Phone: 0300 123 6780
Email: lhscustomerservice@lancashire.gov.uk
Your ref: 03/2015/0305
Our ref: LHS/CS/03/2015/0305
Date: 14th May 2015

Proposal:	Demolition of Storage Building and Erection of Rural Workers Dwelling.
Location:	Dunsop Bridge Trout Farm Dunsop Road Dunsop Bridge Lancashire BB7 3AX
Grid Ref:	365797 - 449752

Existing Site Plan
1:100 Scale

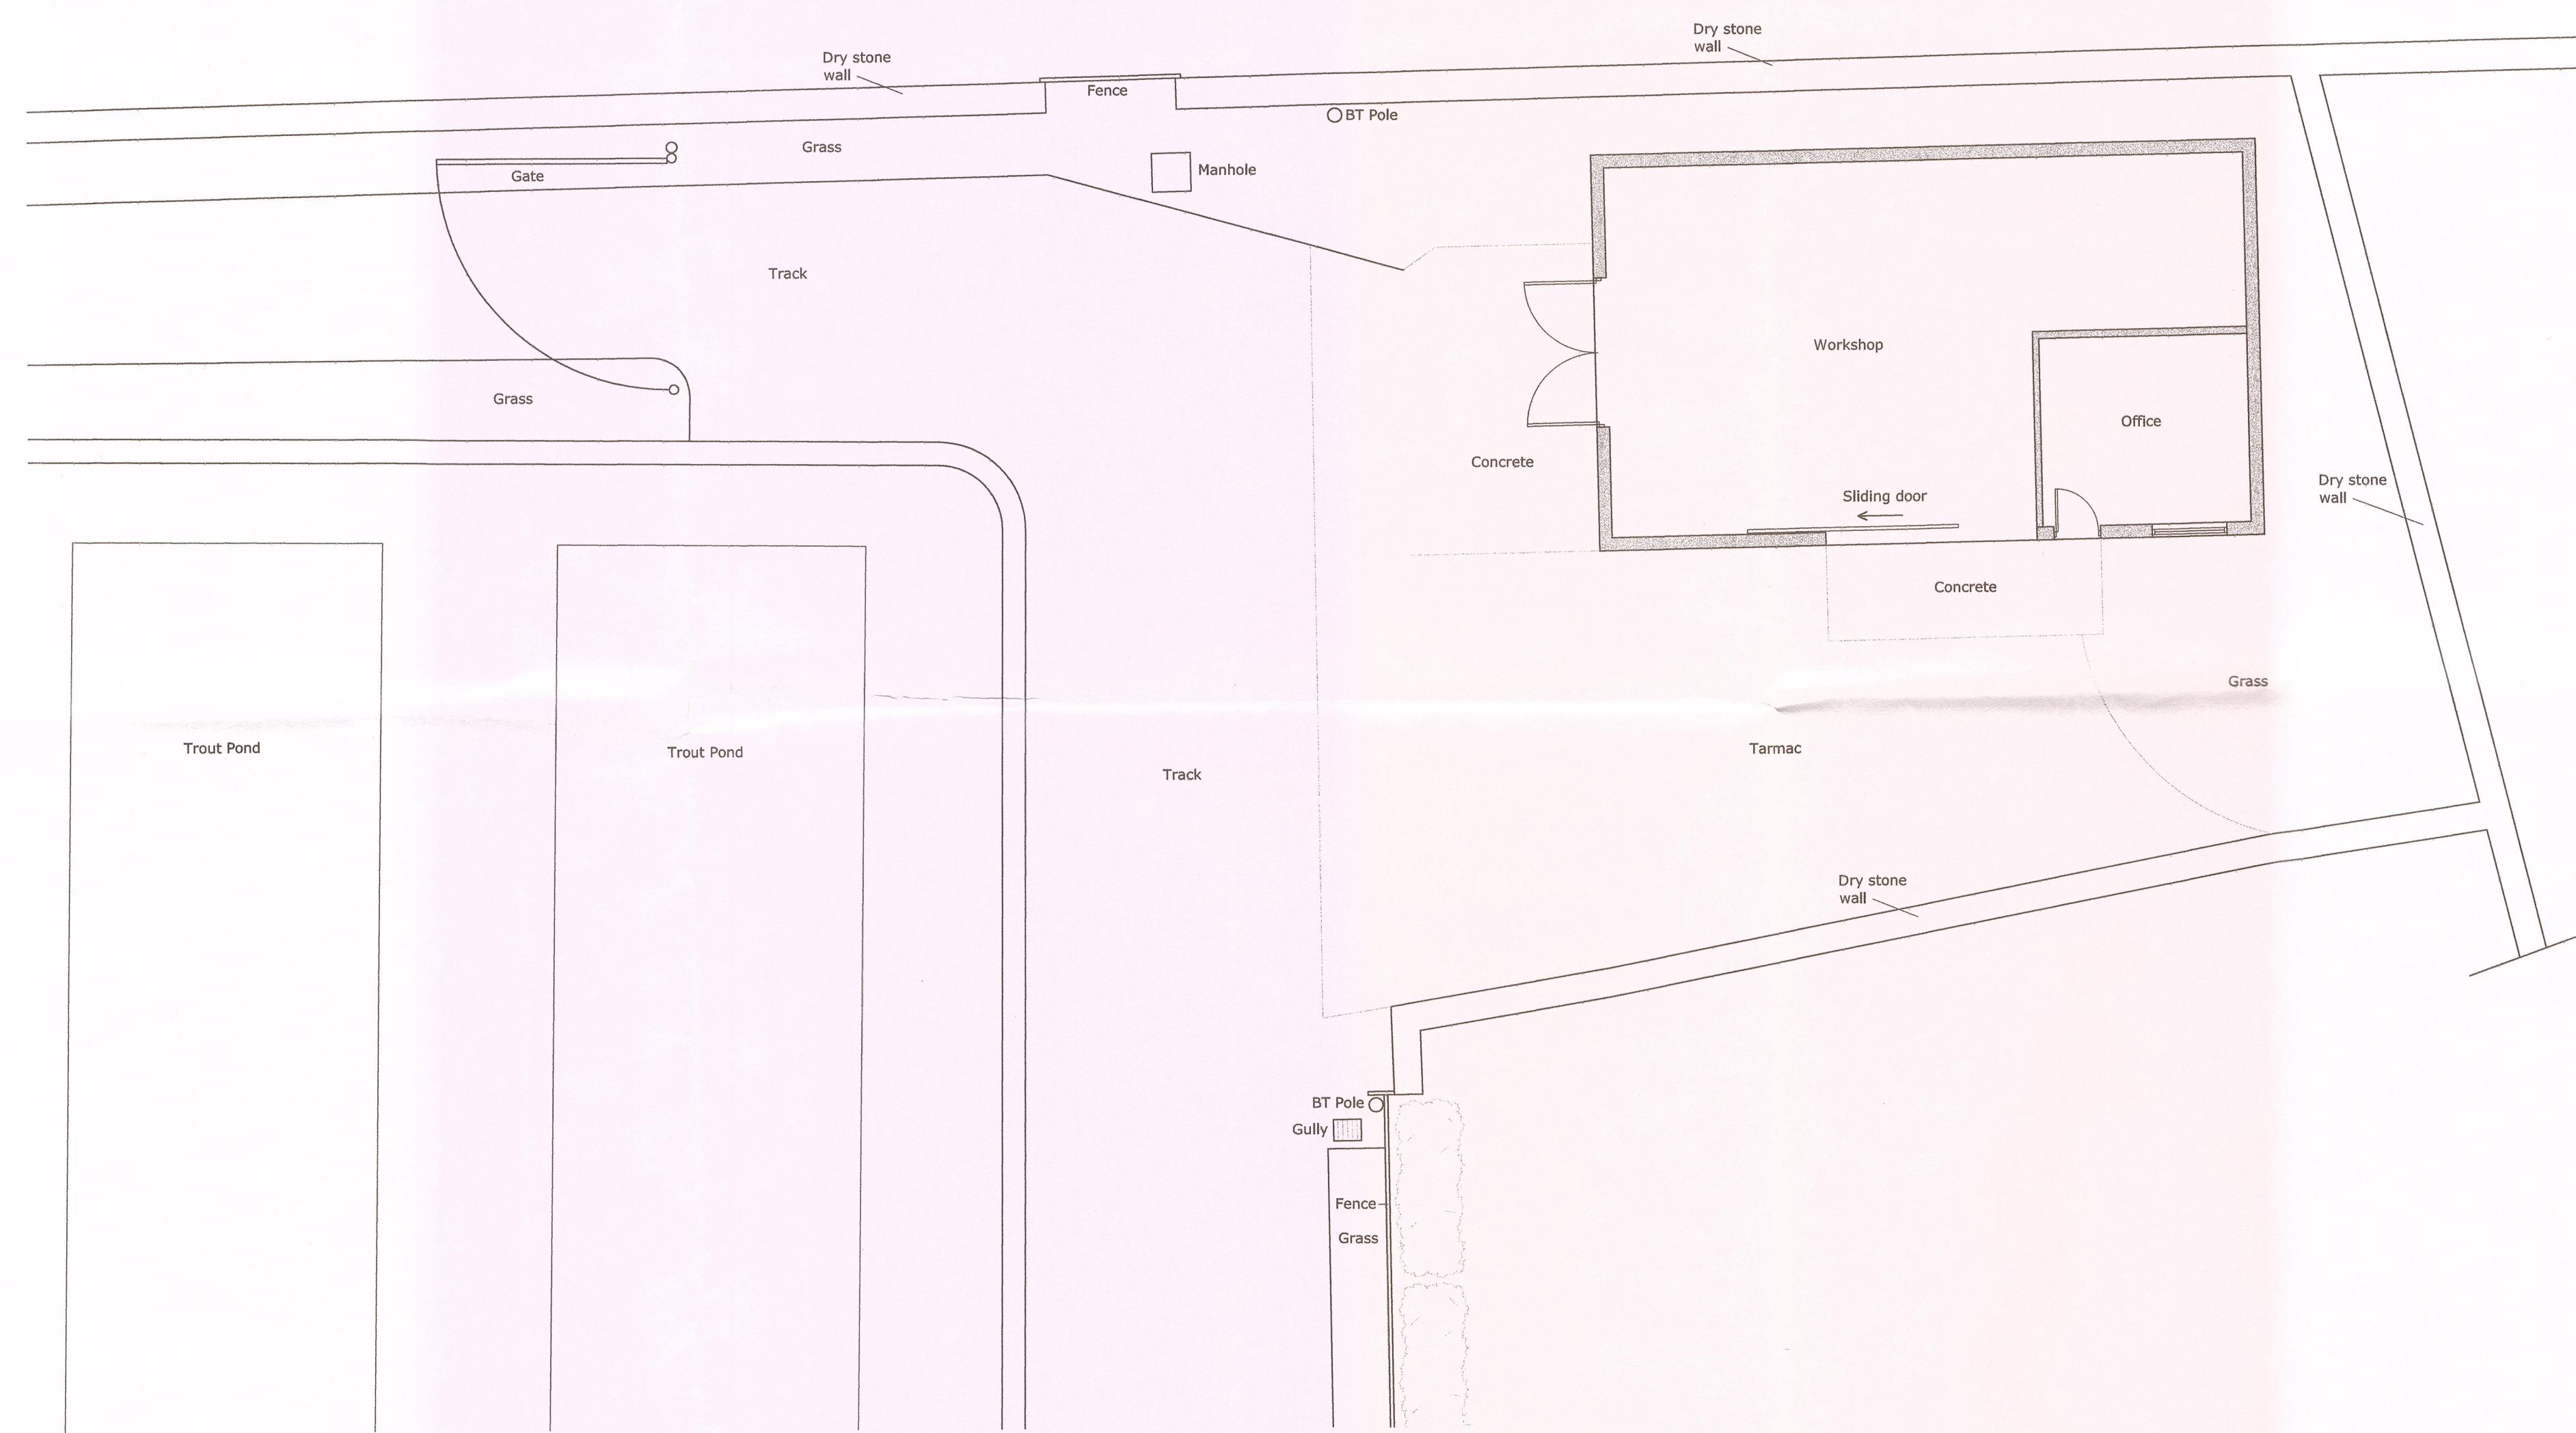
1. No part of the development shall be commenced until the visibility splays measuring 2.0 metres by 11 metres in both directions to be provided, measured along the centre line of the proposed private drive from the continuation of the nearer edge of the existing carriageway of the existing private access road, to the satisfaction of the Local Planning Authority. The land within these splays shall be maintained thereafter, free from obstructions such as walls, fences, trees, hedges, shrubs, ground growth or other structures within the splays in excess of 1.0 metre in height above the height at the centre line of the adjacent carriageway.

2. The car parking and manoeuvring scheme to be marked out in accordance with the approved plan, before the use of the premises hereby permitted becomes operative and permanently maintained thereafter. Reason: To allow for the effective use of the parking areas.
3. Notwithstanding the provisions of the Town and Country Planning (General Development Procedure) Order 1995 and the Town and Country Planning (General Permitted Development) (Amendment) (No 2) (England) Order 2008, or any subsequent Orders or statutory provision re-enacting the provisions of these Orders, all garages shown on the approved plan shall be maintained as such and shall not be converted to or used for living accommodation without the prior written approval of the Local Planning Authority in consultation with the Highway Authority.
